**From:** Amanda Scholes on behalf of Planning.Responses  
**Sent:** 11 June 2020 09:11  
**To:** Planning Scanning  
**Subject:** FW: Planning Consultation on F/9/20/DOC  
**Attachments:** Ag Invest - Wicks Farm - ADC - SuDS - Discharge of Conditions - 30th March 2020.pdf; Ag Invest - Wicks Farm - ADC - Reservoir Design - 9th June 2020.pdf; Ag Invest - Wicks Farm - ADC - Polytunnels - CEP - Flood Risk Assess - 17th January 2019.pdf; Ag Invest - Wicks Farm - ADC - Polytunnels - CEP - Flood Risk Assess - App 1 - 17th January 2019.pdf; Ag Invest - Wicks Farm - ADC - Polytunnels - CEP - Flood Risk Assess - App 2 - 17th January 2019.pdf

**APPLICATION NO:** F/9/20/DOC

**Site Address:** Wicks Farm Ford Lane Ford BN18 0DF

**Description of Works:** Approval of details reserved by condition imposed under ref F/30/18/PL relating to Condition No 3 - surface water drainage.

TYPICAL PIPE BEDDING AND TRENCH DETAILS

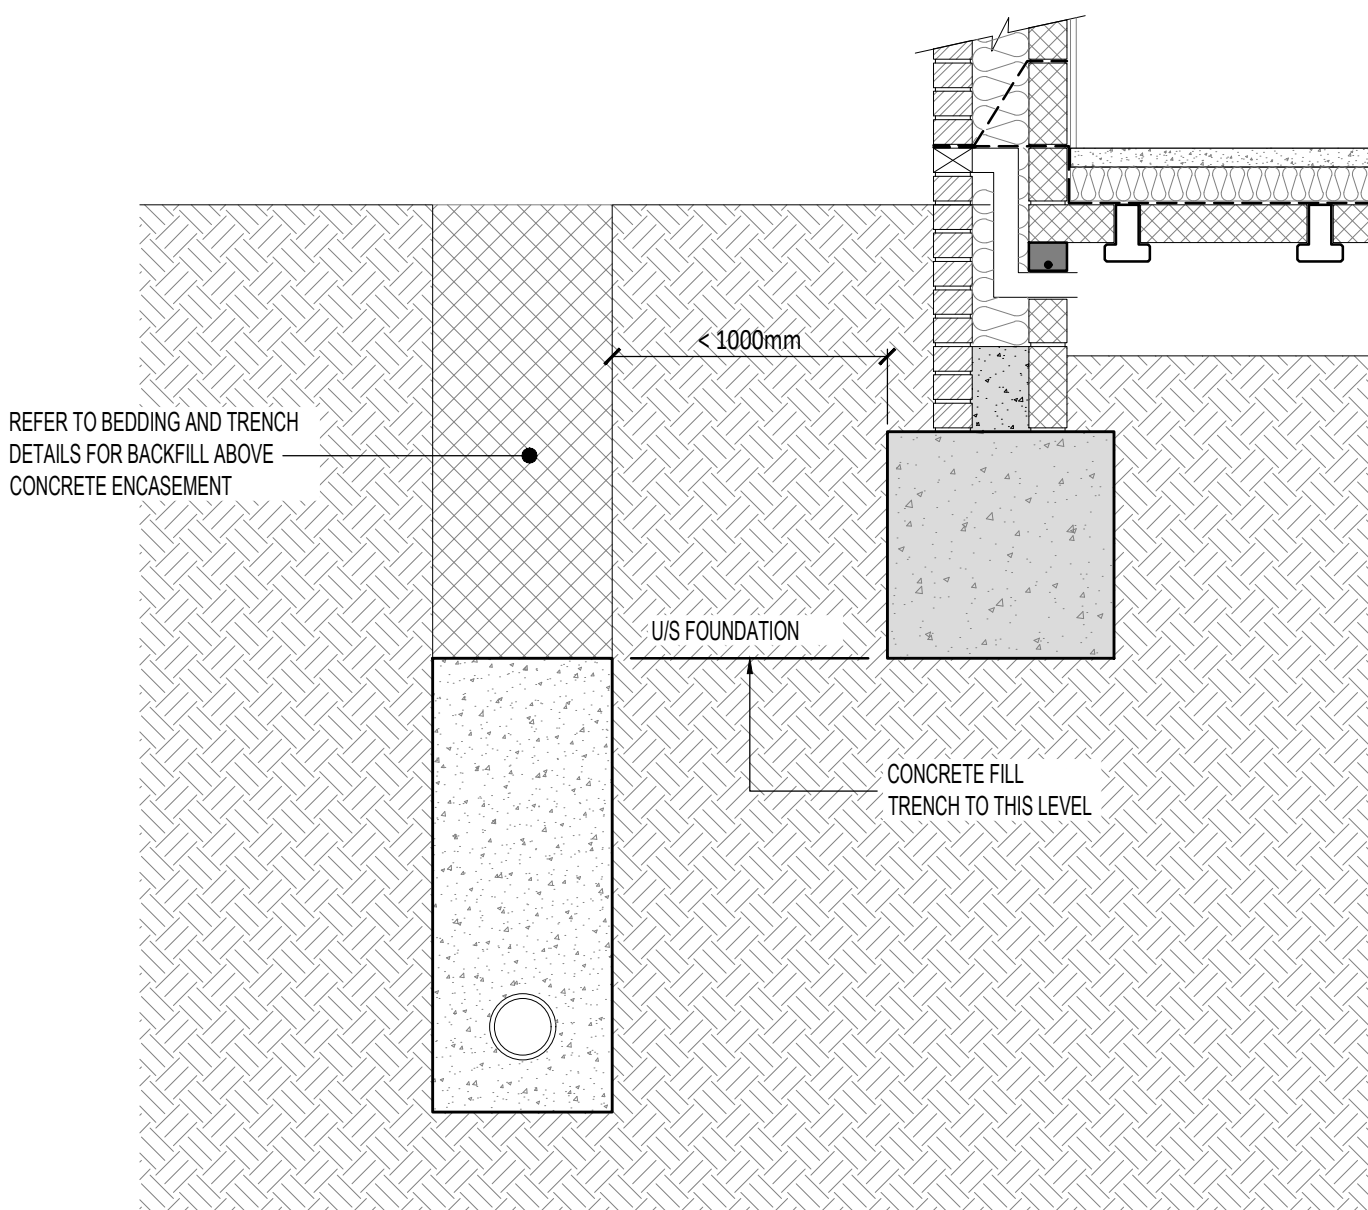
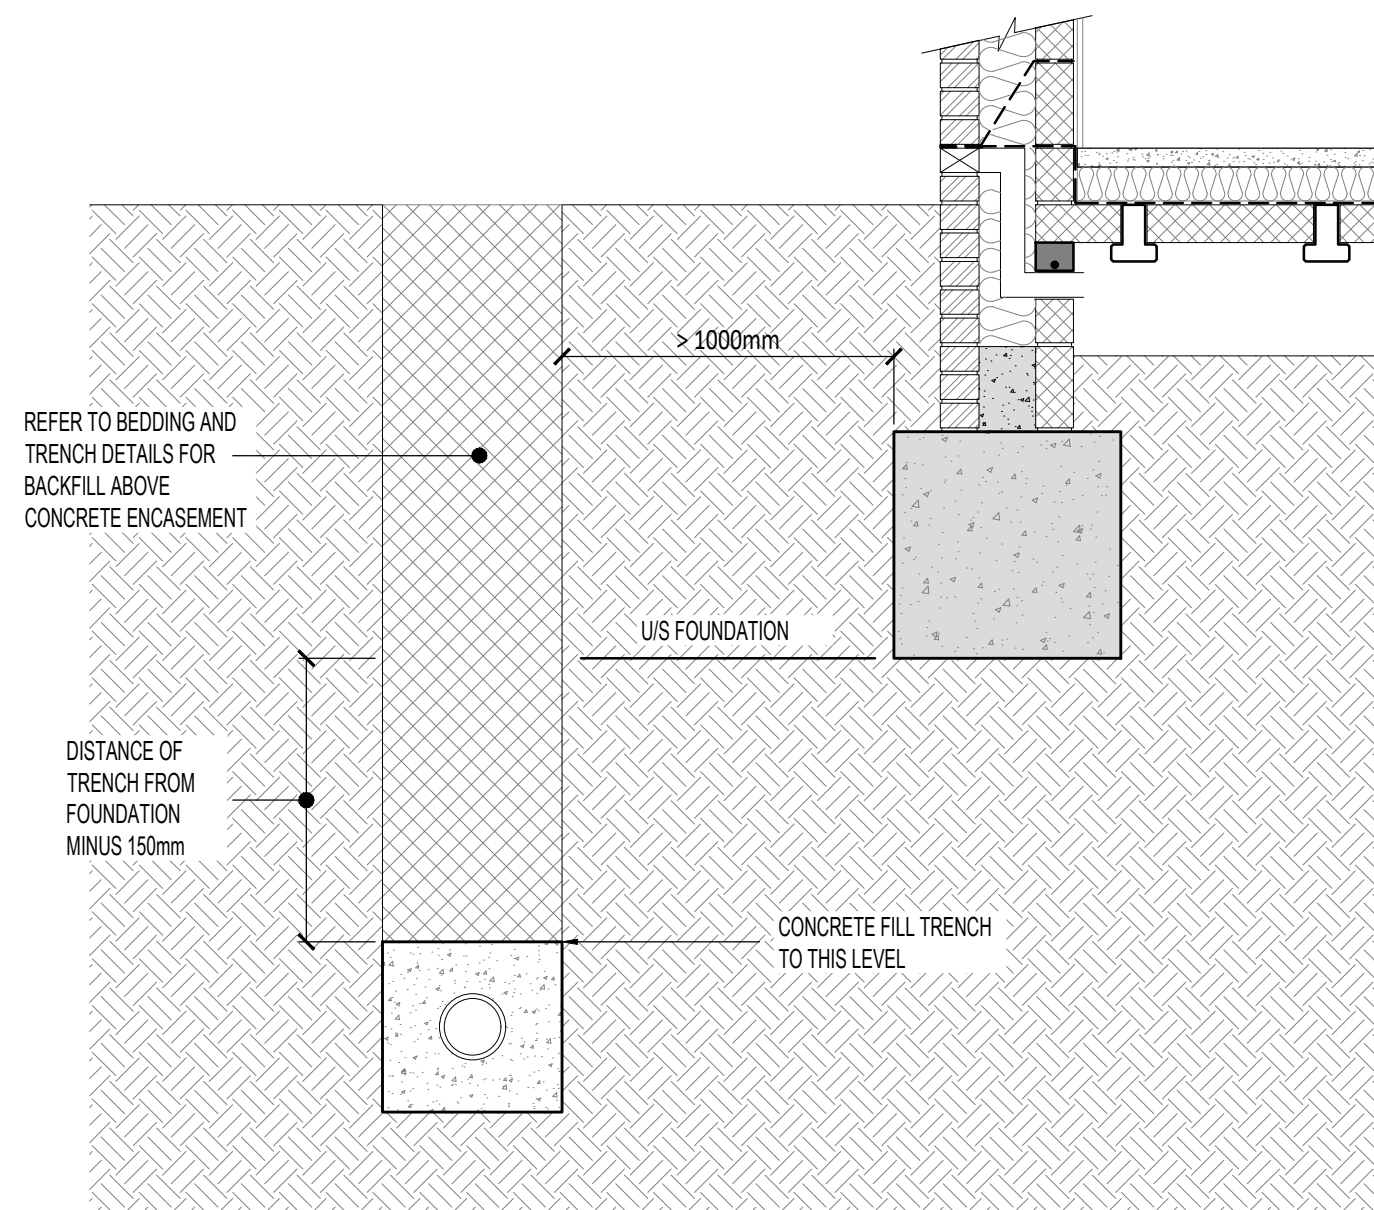
16. Incoming 225mm pipe to swale 2 – provide min. 100mm freeboard between swale bed and pipe invert.
17. Pipe concrete bed and surround detail – specify the specific concrete mix on the detail itself.
